Environmental Assessment Submission

National Ceramics Industries Australia
Part 3A Major Project – MP09_0006

Submitted by: Farley Investigation Area Landowners Group

Figure 4 Nearest Potentially Affected Noise Sensitive Receivers

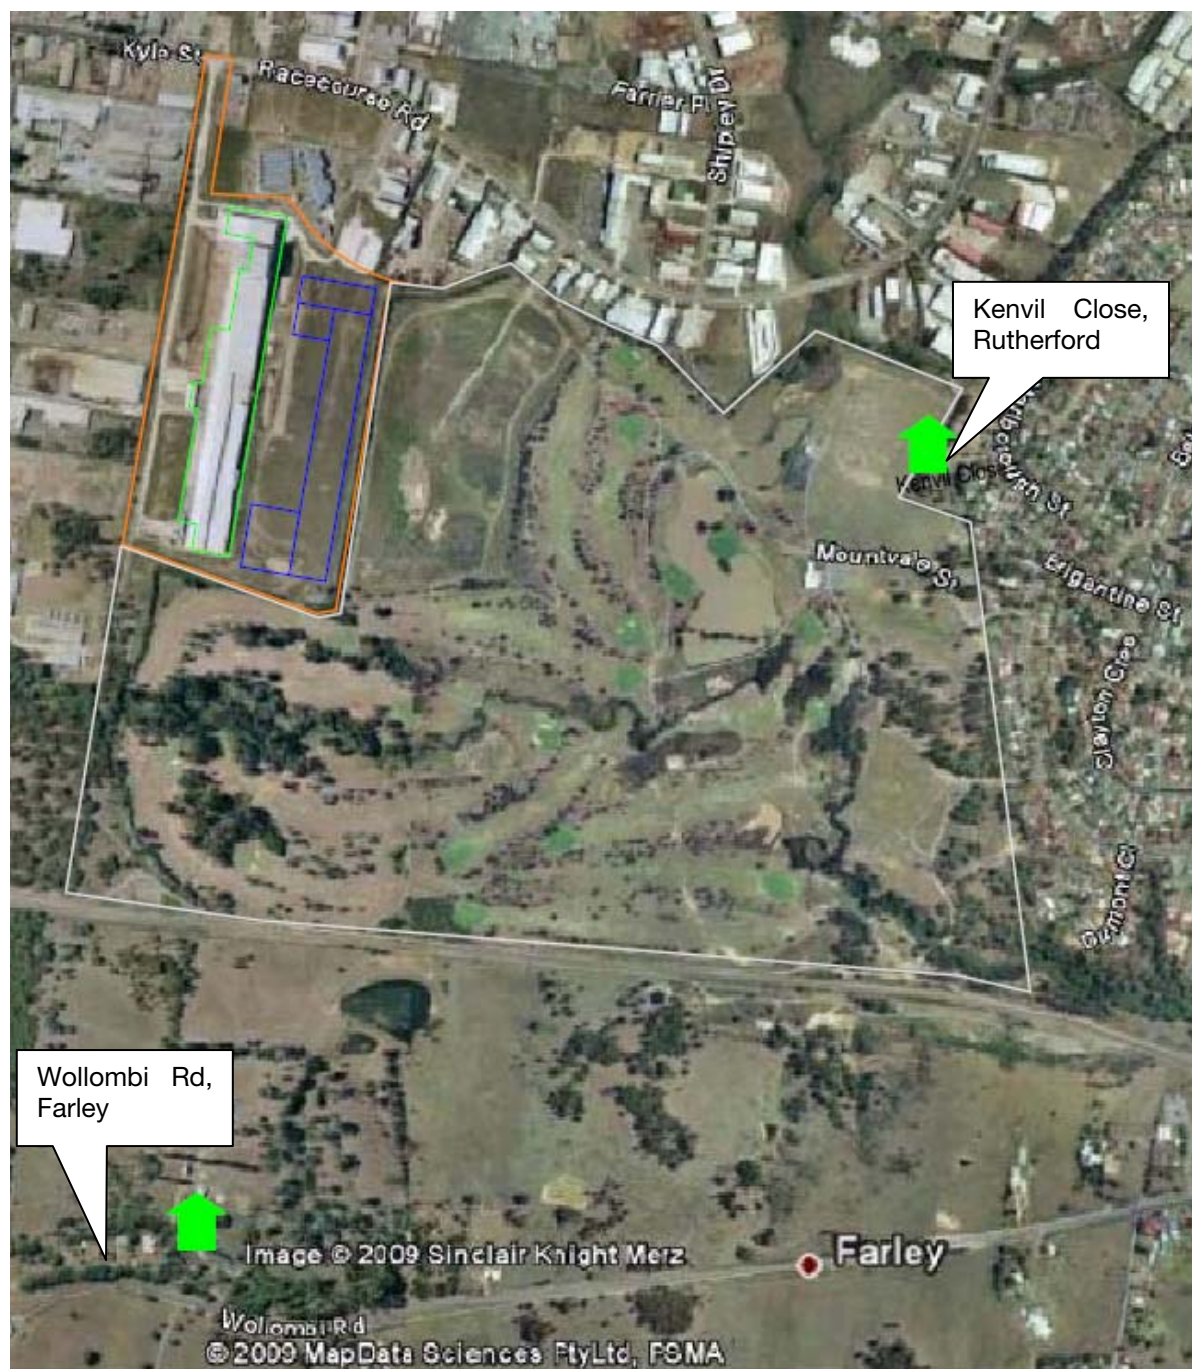
- There are a number of collection and modelling methodological issues and anomalies with noise data that devalue the EA's conclusions:
 - There was only one noise logger south of the railway line at 256 Wollombi Road and it was NOT at the location identified as the nearest potentially affected noise-sensitive receiver along Wollombi Rd (EA Appendix E, Figure 4, p7)

- The EA identifies the nearest sensitive receiver south of the railway line as “located approximately 860m from the site boundary.” (EA, p64). As the northern boundary of the FIA is the rail corridor there is clearly the potential for many sensitive receptors to be impacted considerably closer than the identified receptor.

- NCIA need to acoustically assess the FIA to account for all existing and future sensitive receptors. The assessment must detail the environmental impact to these receptors, articulate intended mitigations and quantify any residual impacts.
- The Department of Planning should retain the noise emission limits within the existing consent. And if retained, NCIA need to indicate the acoustic mitigation measures proposed to negate the encroachment of the 35dBA noise contour into the FIA.
- NCIA need to undertake additional noise attenuation strategies that preserve the acoustic amenity of the surrounding vicinity.
- The Department of Planning should condition as part of any consent the implementation of the mitigation and management assumptions used in the acoustic modelling.

Noise Contours - Proposed Operations (Temperature Inversion)

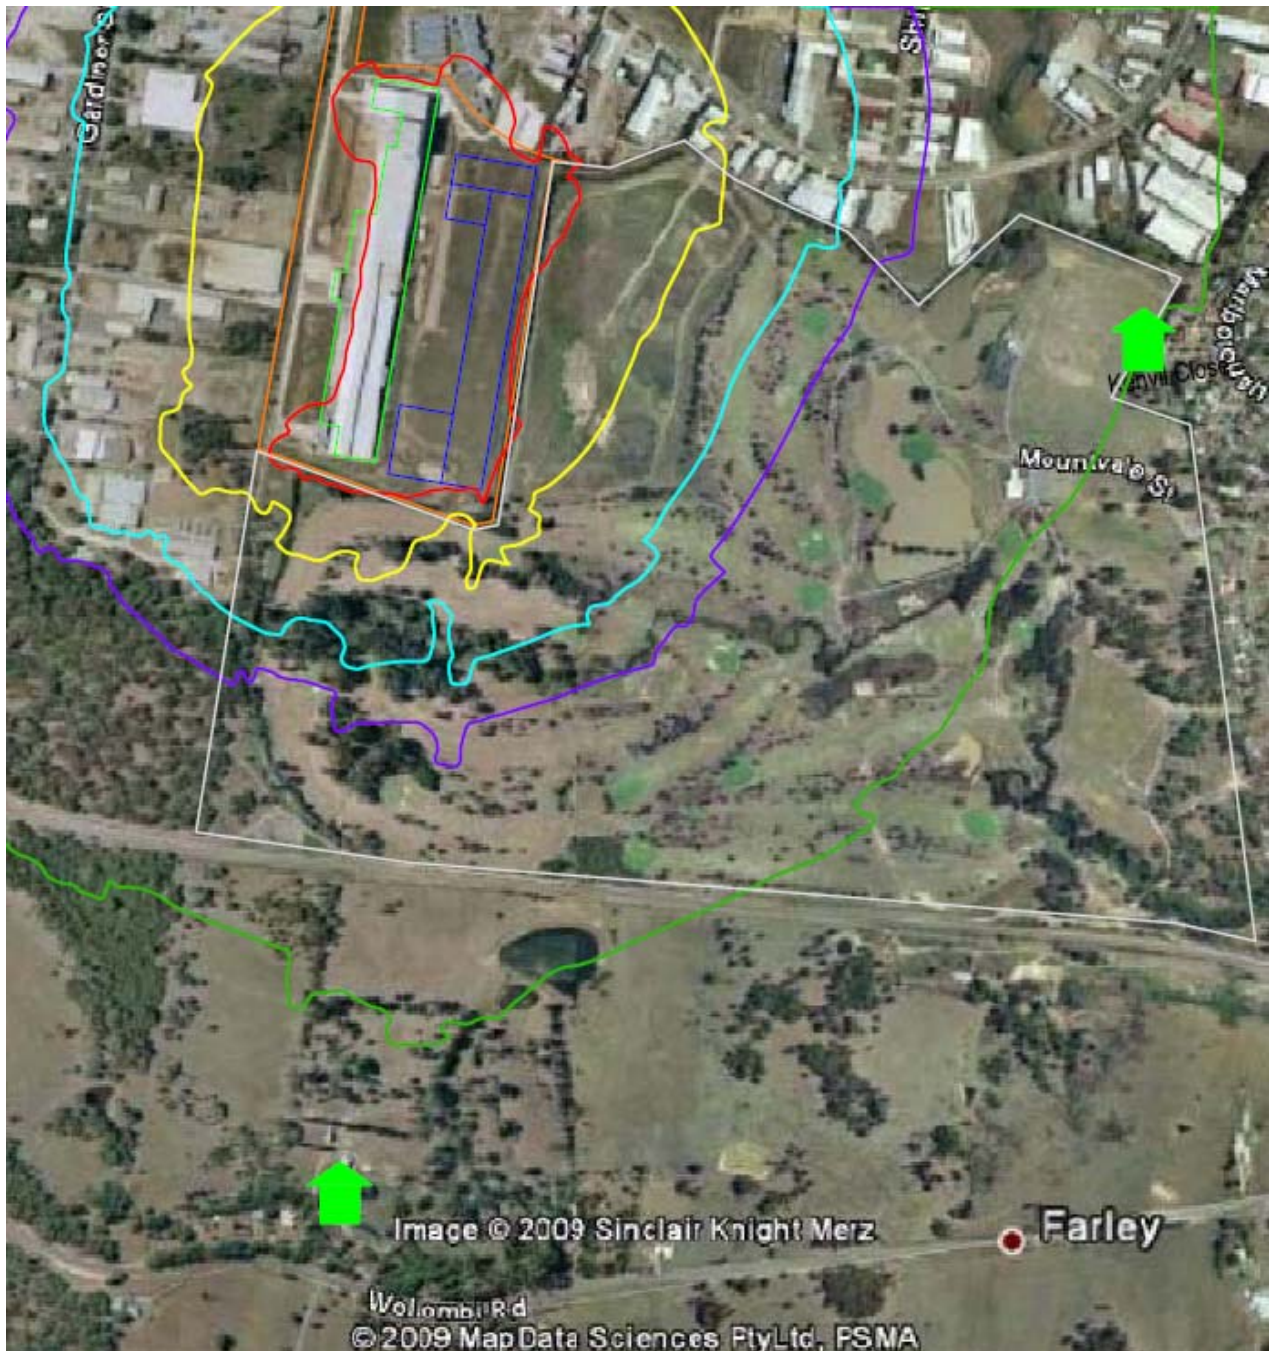
- Even under the existing NCIA noise emission consents, where the maximum daytime allowable limit is 35 dBA parts of the FIA are being impacted. The EA indicates that the 35dBA contour extends into the FIA, quite considerably under temperature inversion and north-west wind conditions (EA Appendix E Noise Impact Assessment – Appendix C2 & C4 respectively).
